9 August 2022
Ref: 30N-21-0300-ADM-39827-0

Greenwich Hospital, NSW

Vipac Engineers and Scientists completed a wind tunnel test and issued a report in March 2022 on the proposed development for the Greenwich Hospital Redevelopment (30N-21-0300-TRP-29254-1). Plans of the updated design were supplied in August 2022 from Bickerton Masters (Hospital wing only). A comparison was made with the findings in the March 2022 report. The observations and findings are as follows:

REVISION:
P18
DATE:
DRAWING TITLE:
H&C - OVERALL PLAN - L2

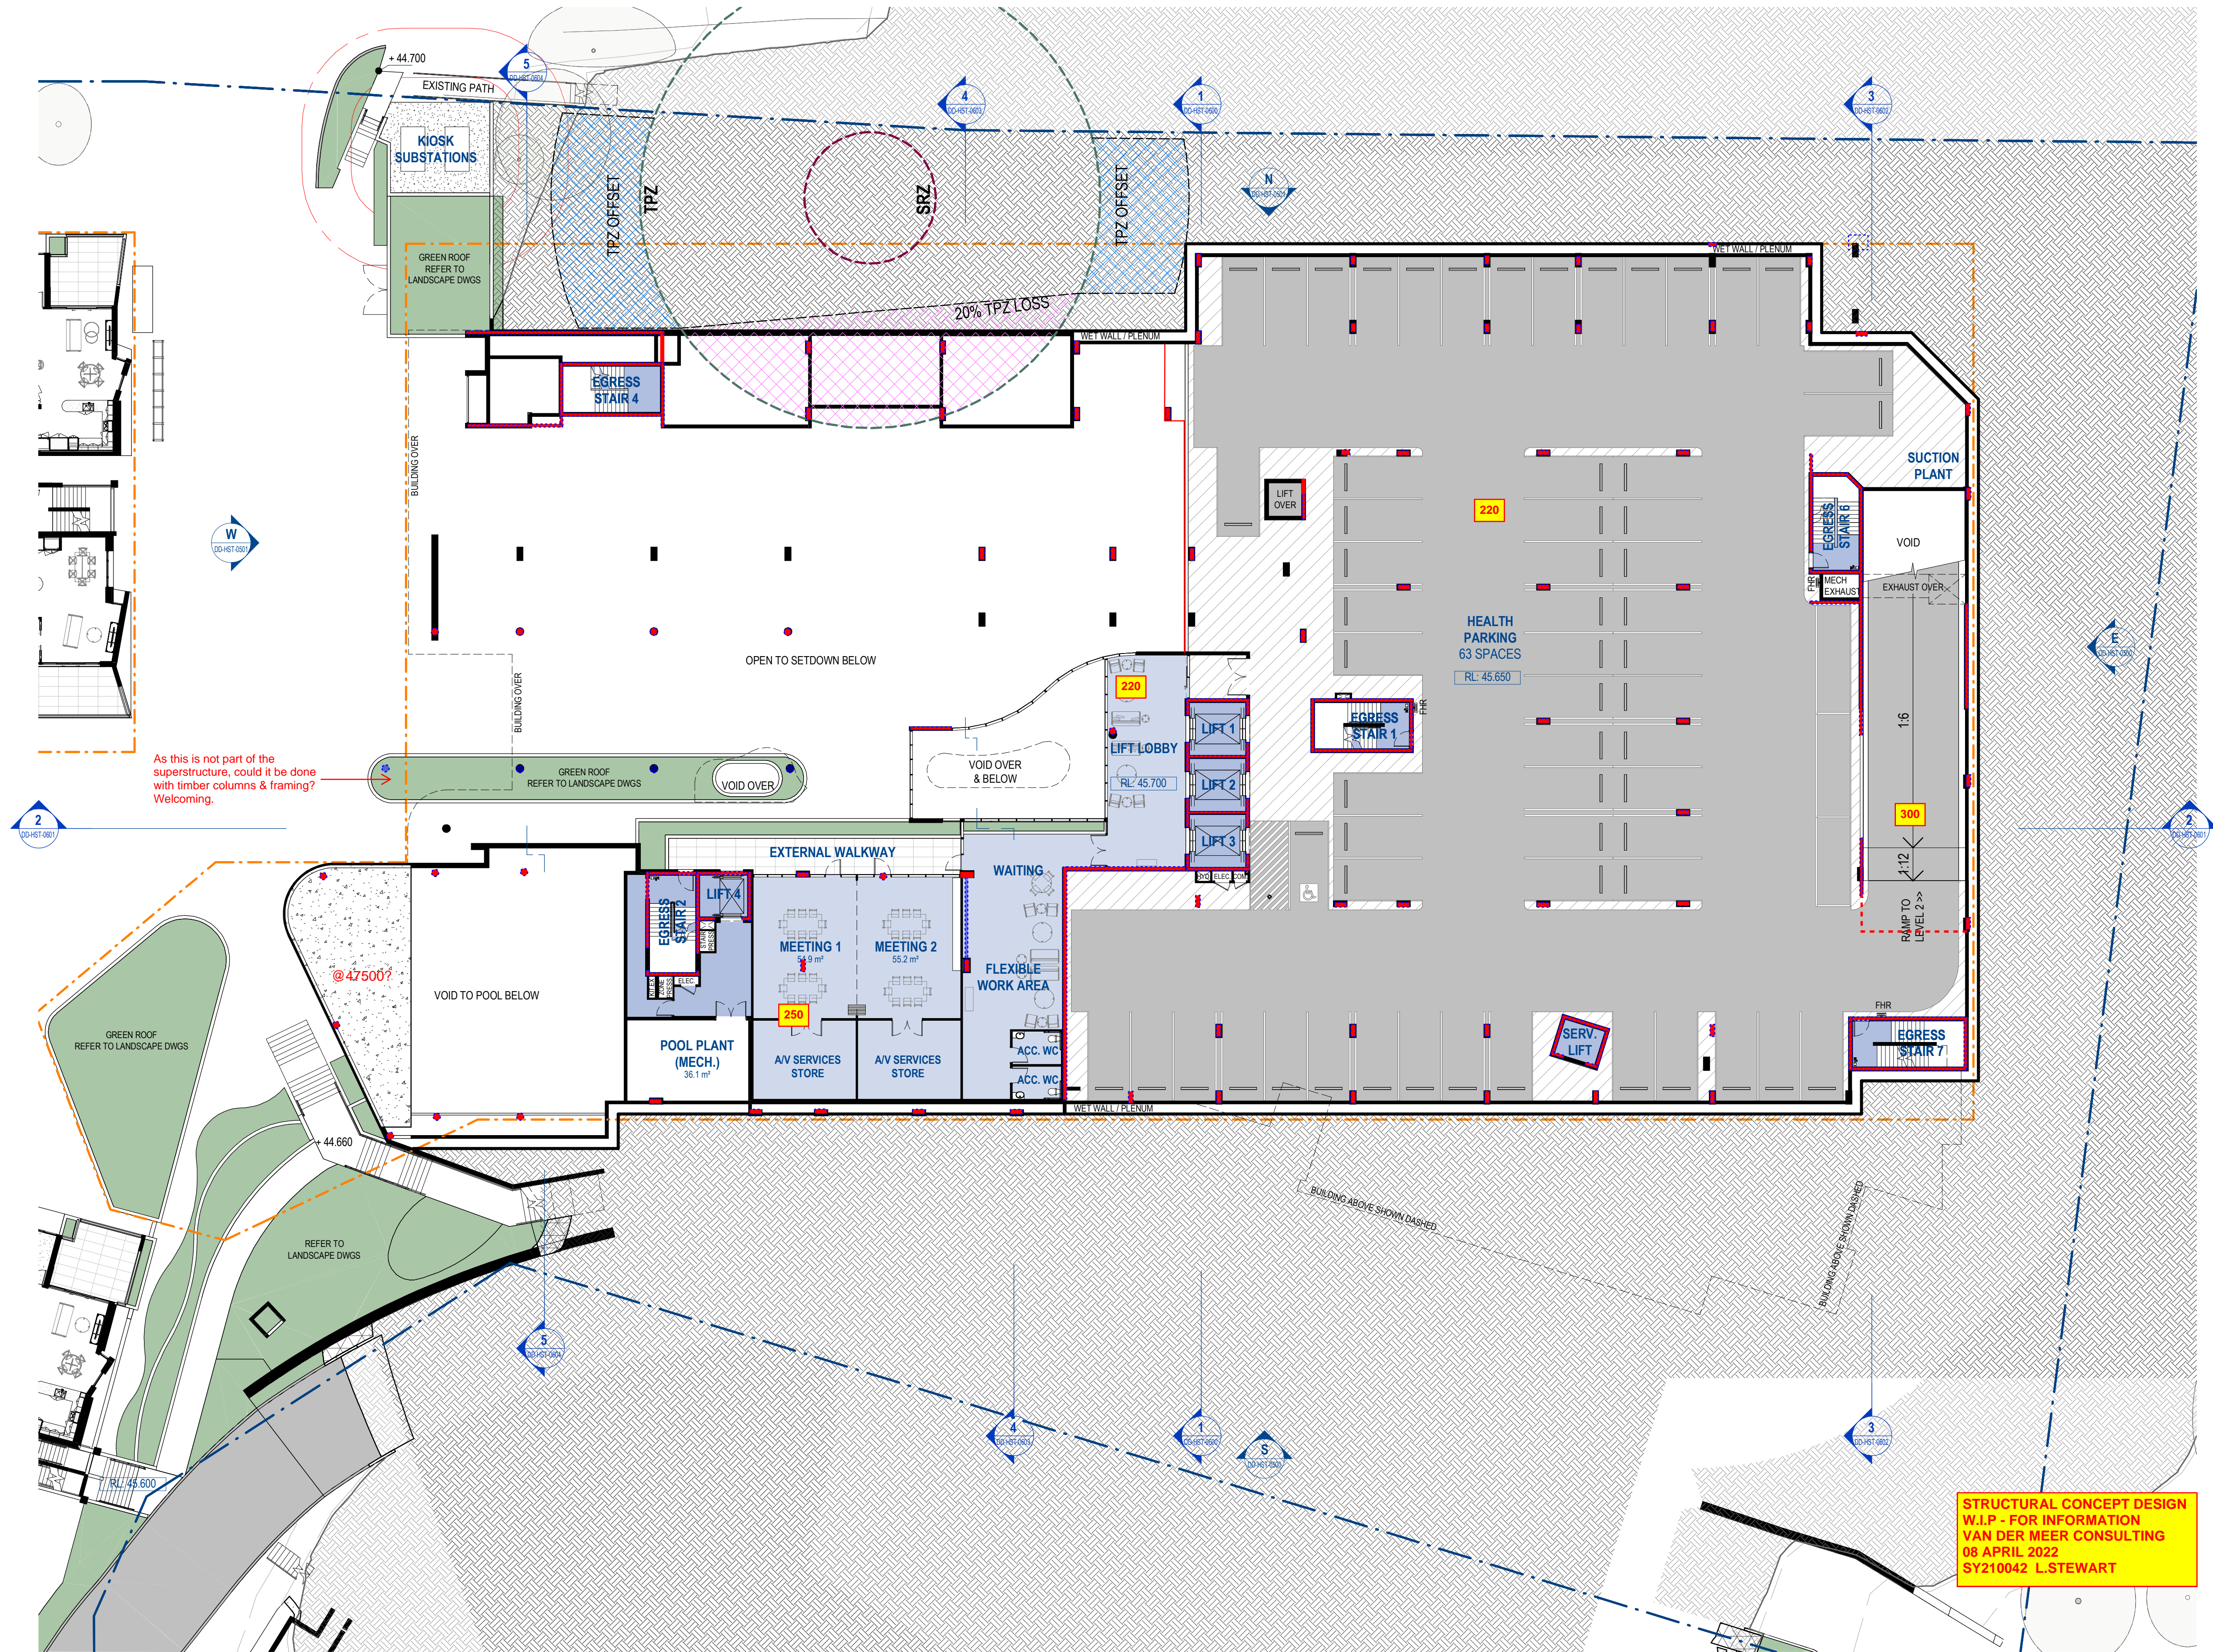
- i) An Oxygen Store, Generator and Fire Tank have been added on the north of Level 2, however, as these are located under the natural ground line, they are not expected to affect the wind environment (Figure 1);

REVISION:
P17
DATE:
DRAWING TITLE:
H&C - OVERALL PLAN - L6

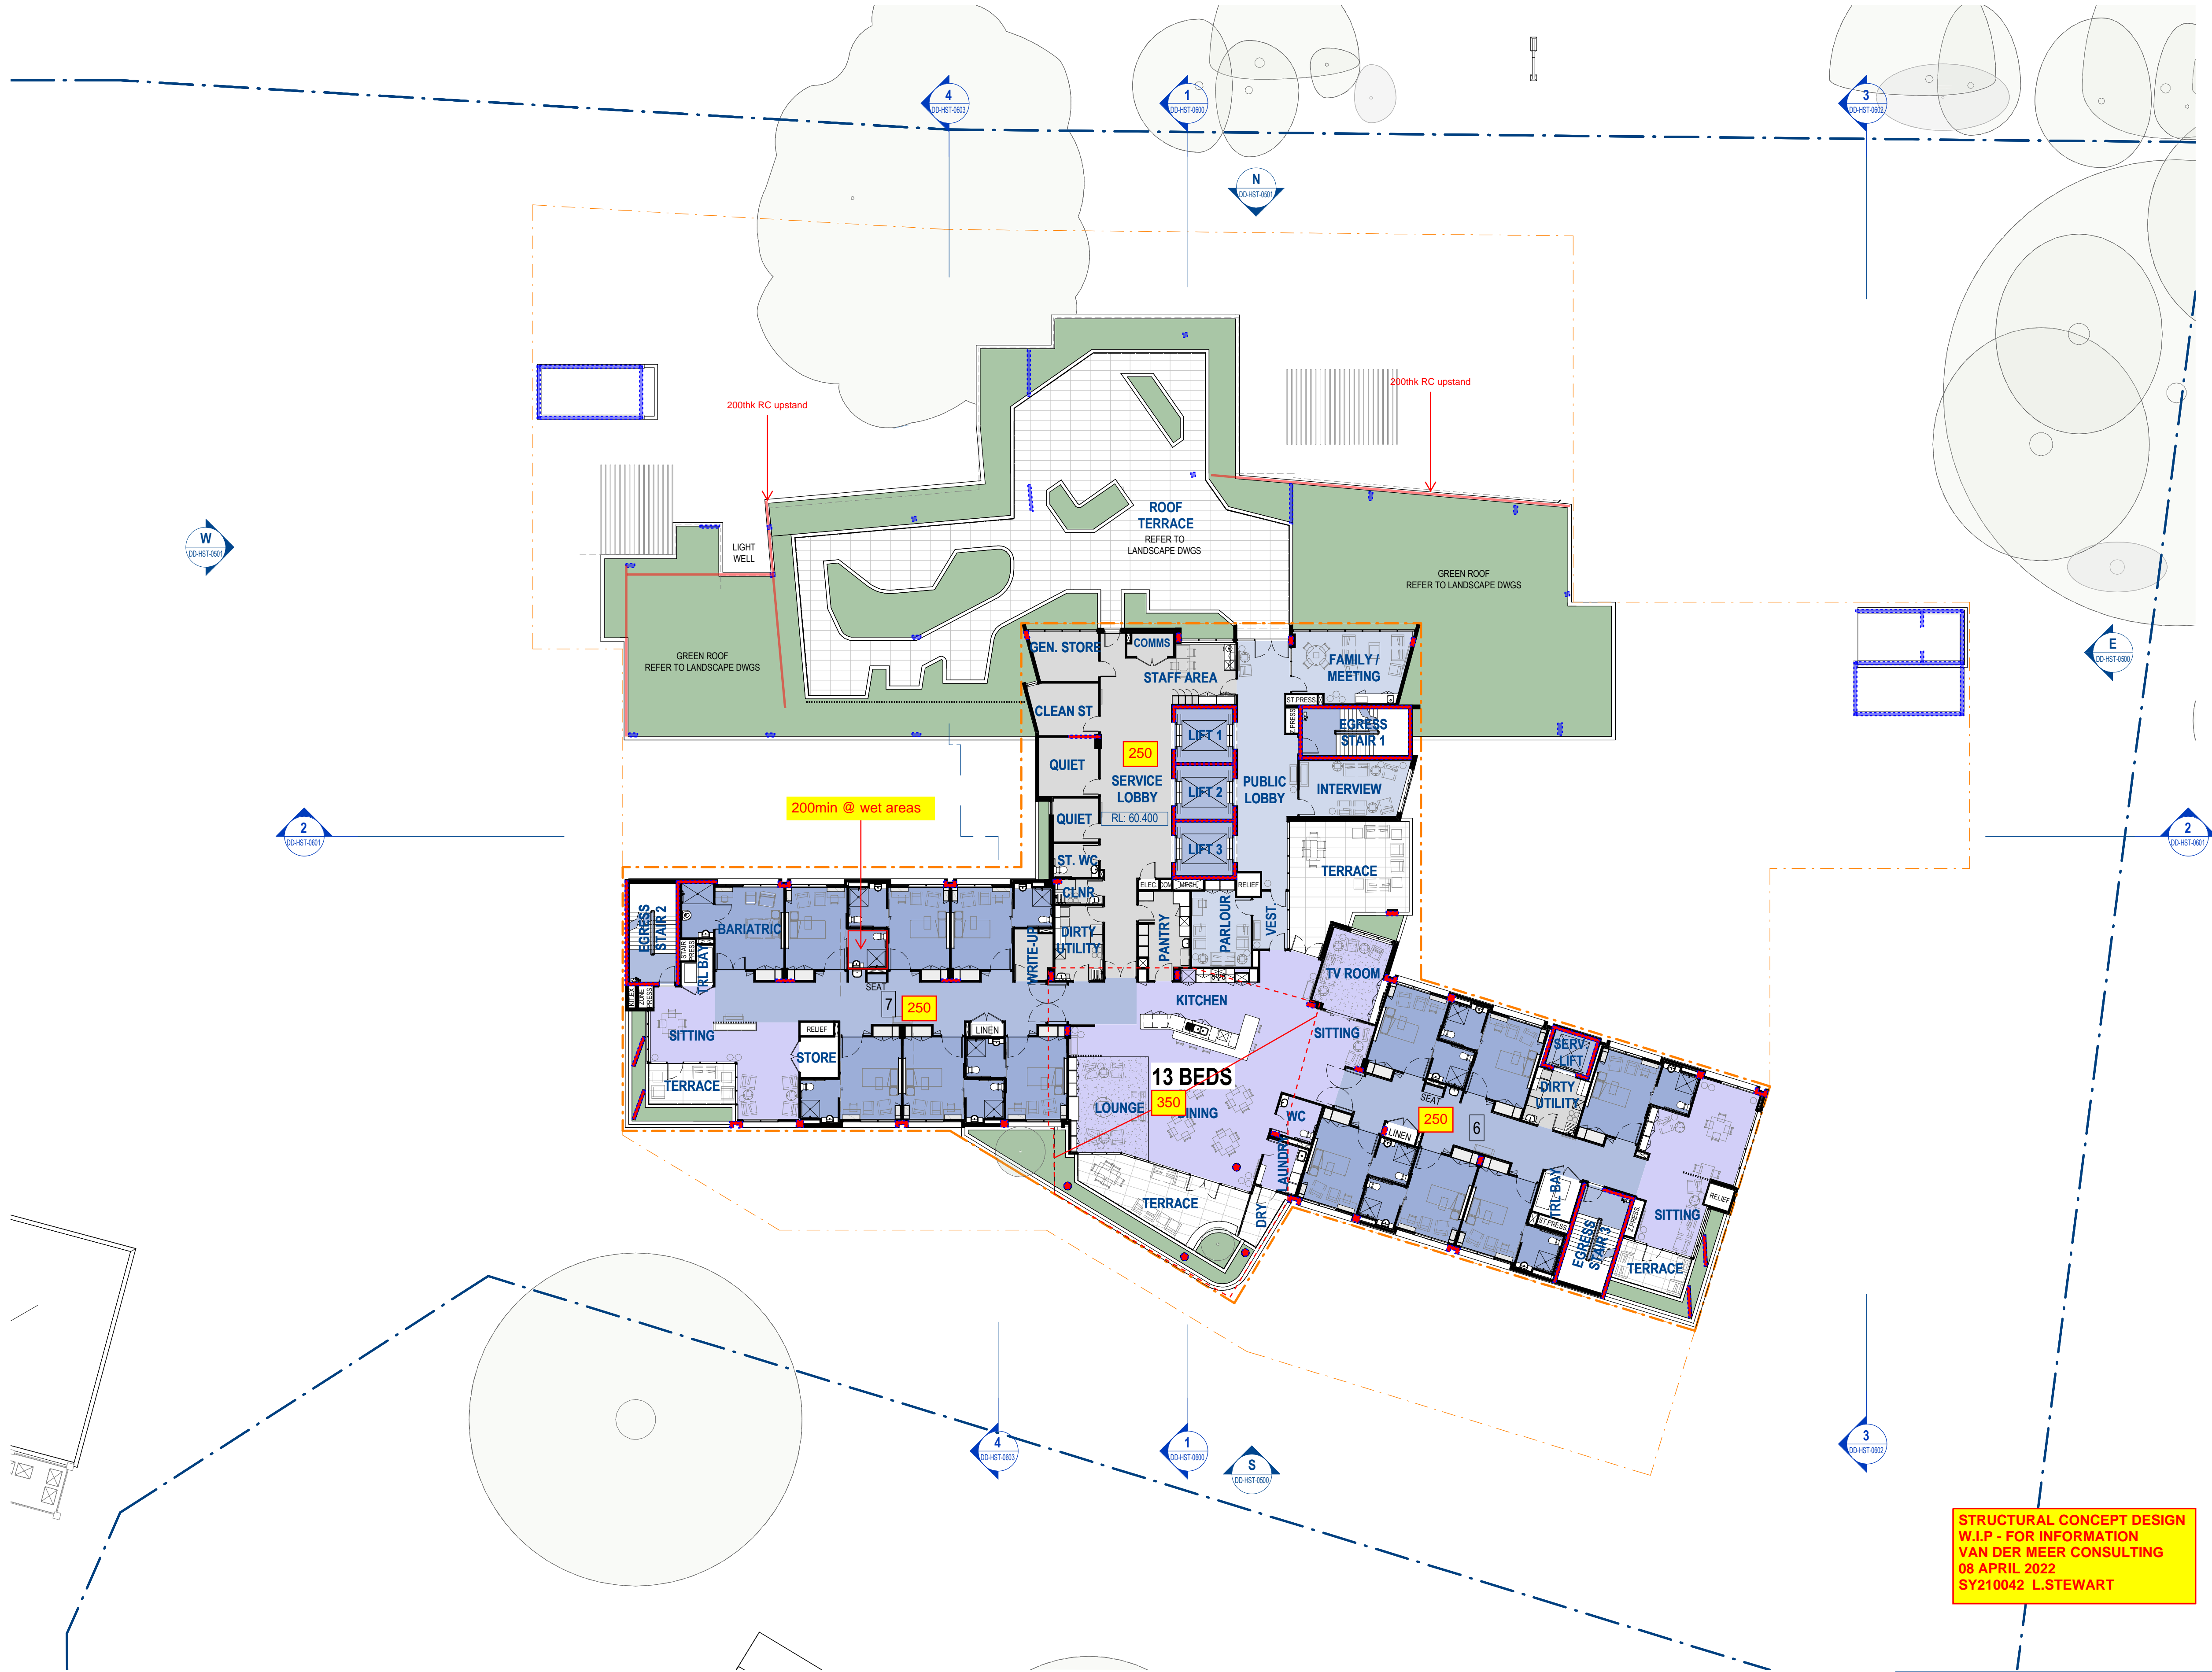
- vi) The extent of the northern terrace on Level 6 has increased in the updated plans, and harbour structures have also been added (Figure 6). Wind speeds at this location are not expected to be significantly different from what was measured in the March 2022 wind tunnel test; and
